## DECISION DELEGATED TO HEAD OF PLANNING

**Application No:** H13-0873-24      **Applicant:** Mr R Bailey

**Proposal:** Change of use of site from scaffold and associated equipment store (approved under H13-1010-96) to use of site restricted within Use Class E(g)(iii)

**Location:** Penns Farm Yard Penns Place Seas End Road

Notes: SITE PLAN.

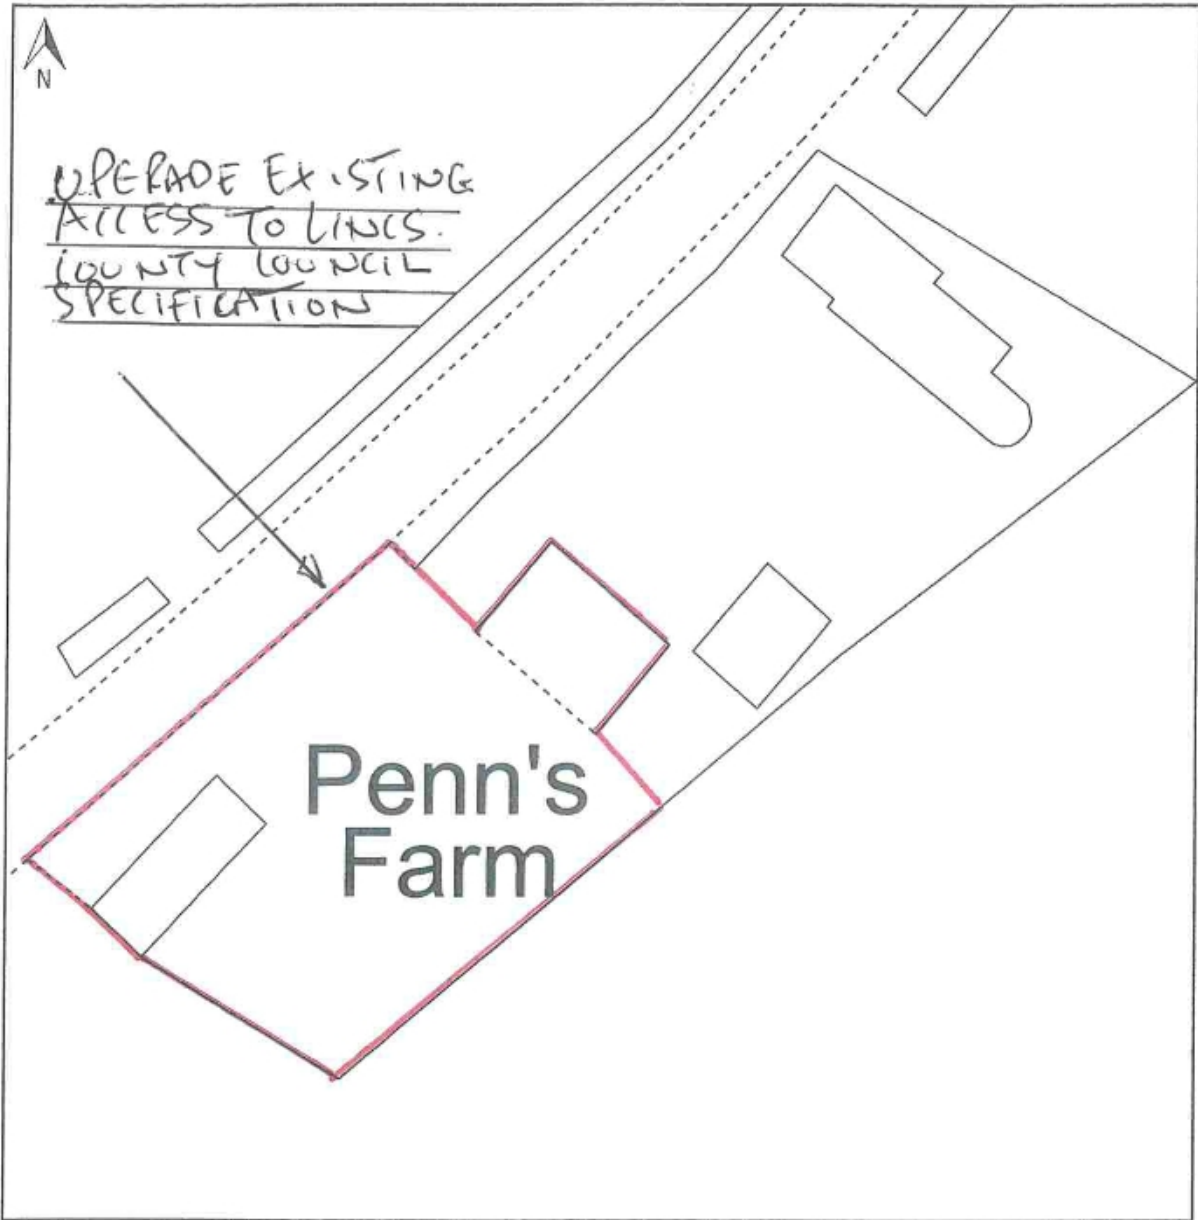
**ADDITIONAL INFORMATION REQUIRED** The access is to be upgraded to Lincolnshire County Council specification and a note should be added to the block plan.

-An additional plan has been received that shows an annotation that the access will be made up to LCC standards.
